KITITAS COUNTY

MEMORANDUM

TO: All Staff
FROM: Justin Turnbull, County Surveyor 
DATE: May 28, 2020
SUBJECT: County Survey Review of BL-20-00012 Greer Tutino

PART OF SECTIONS 8 AND 9,
TOWNSHIP 18 NORTH, RANGE 17 EAST, W.M.

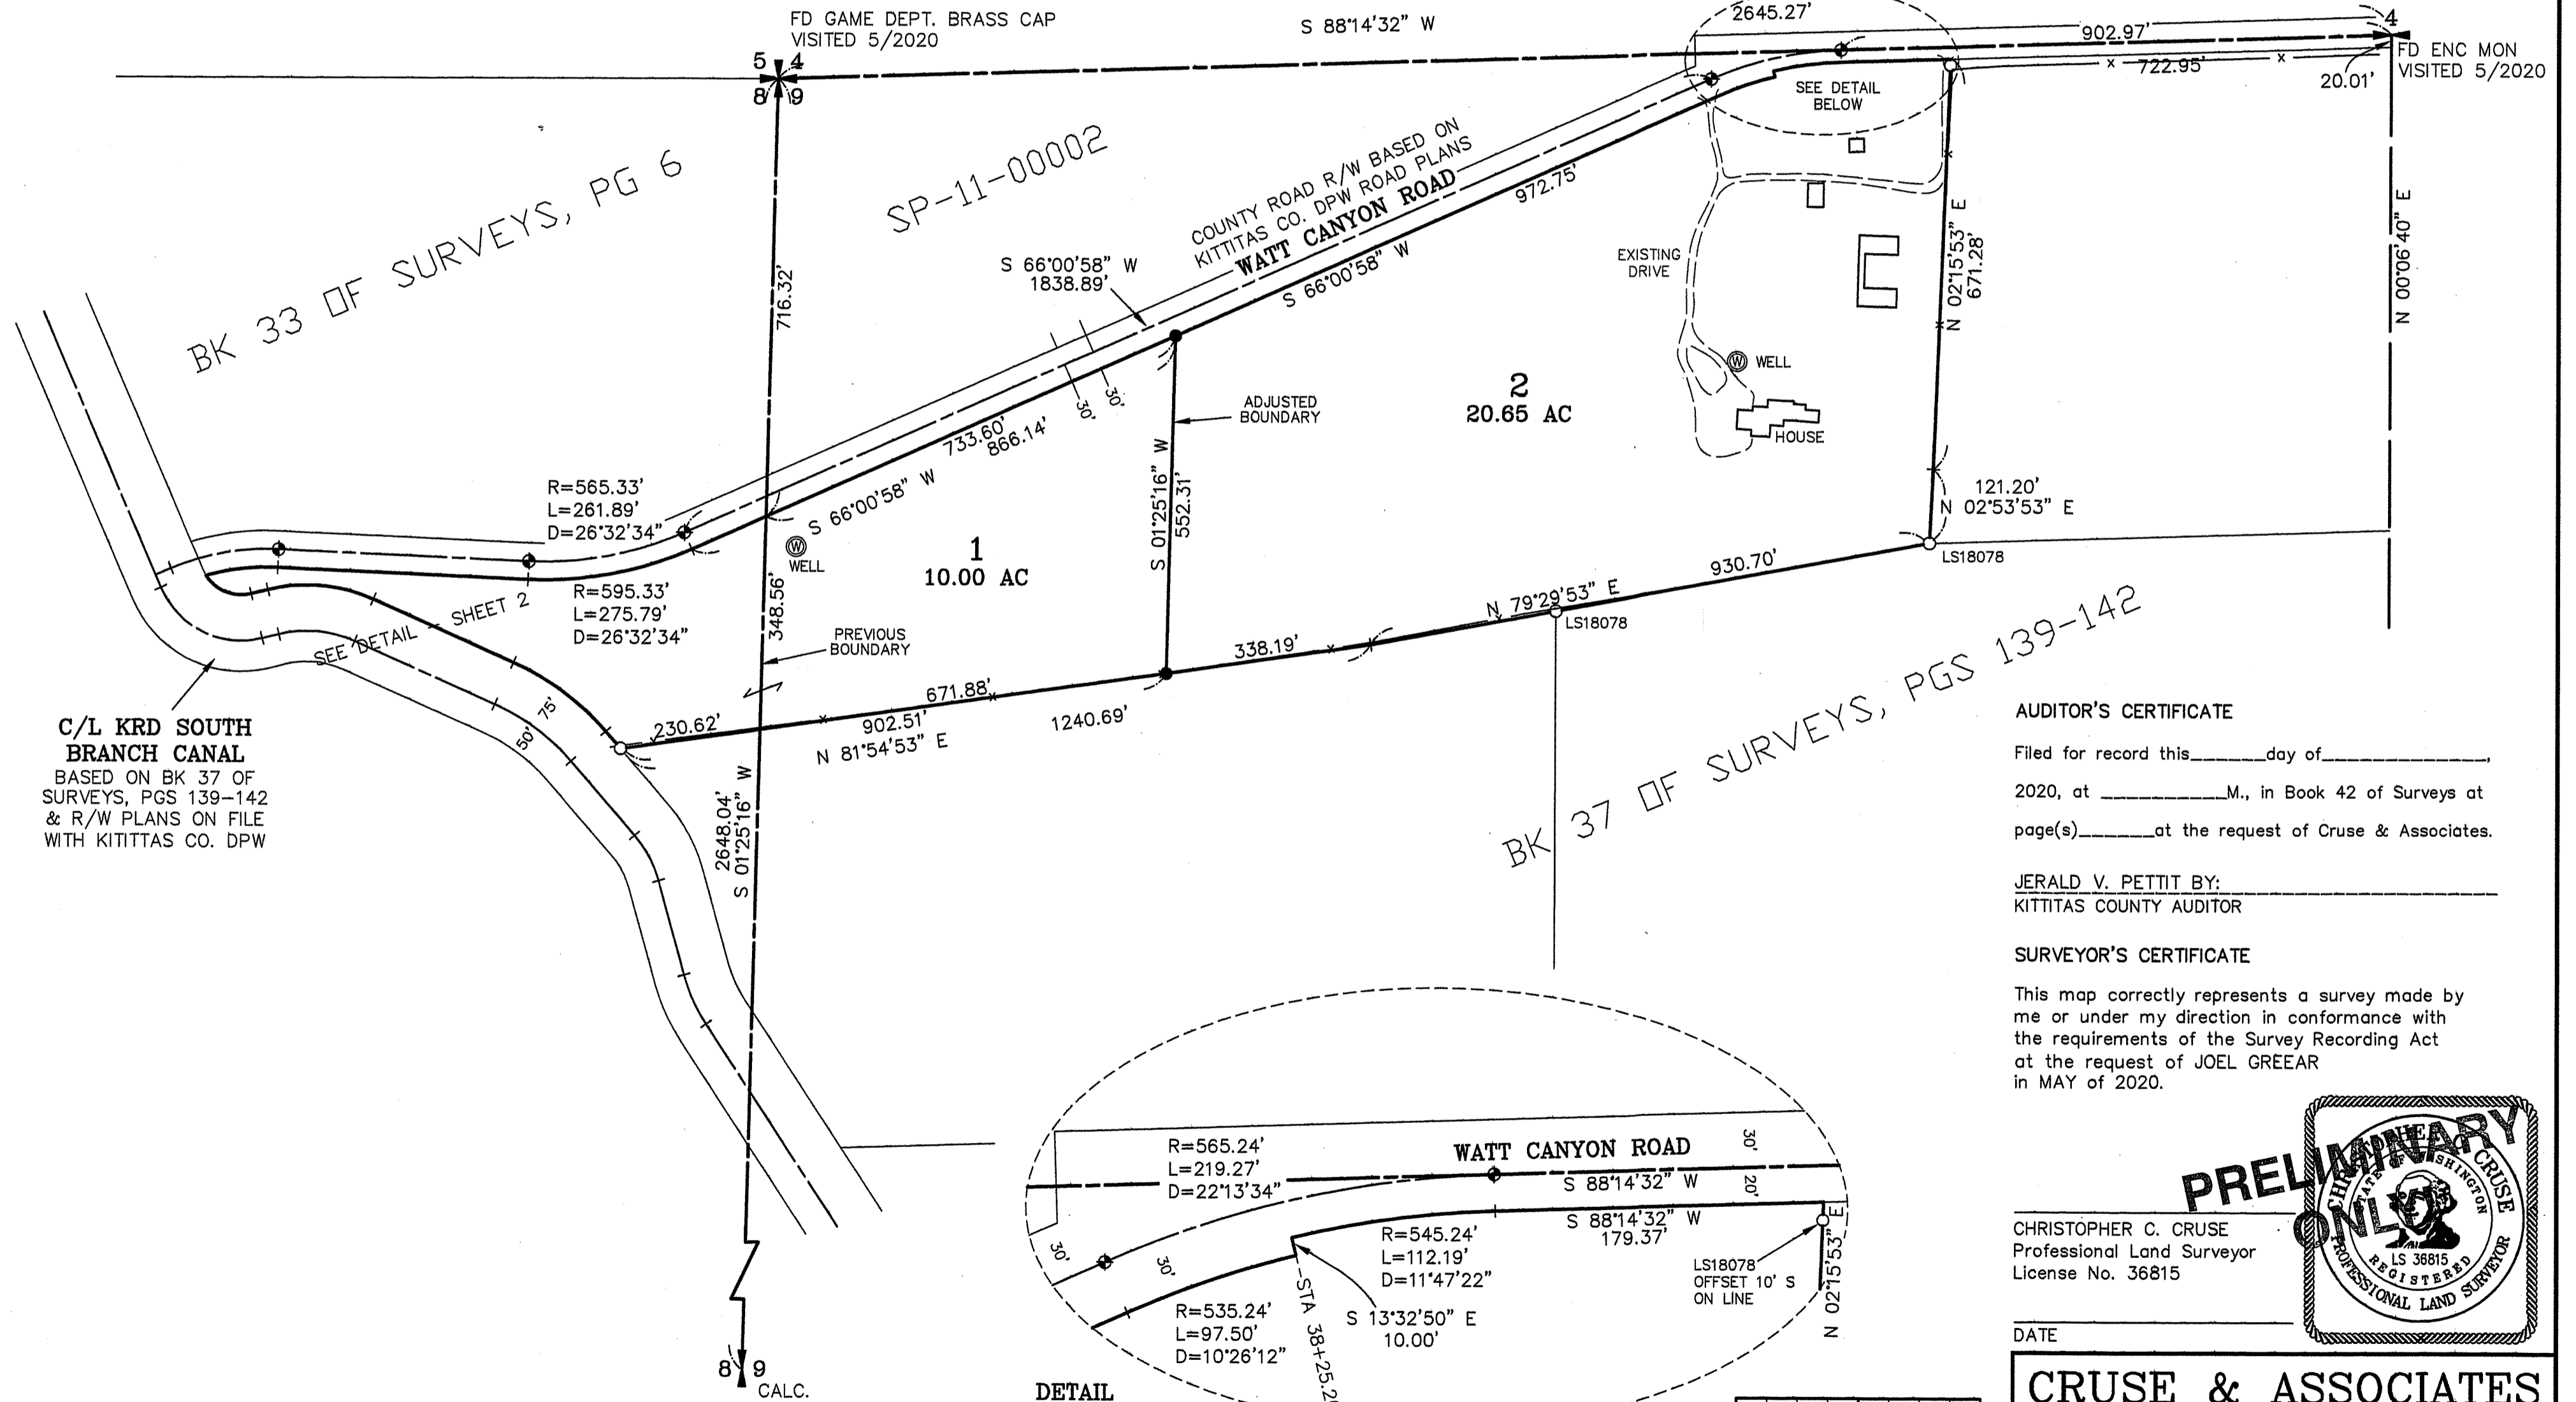
1. The dimension shown East of the NE Corner of parcel 2 is partially obscured by an adjacent line.
2. The westernmost dimension of the North line of Lot 1 has a small (10") discrepancy with the lot closures. (Ch=S83-25-24W vs S83-25-34W)
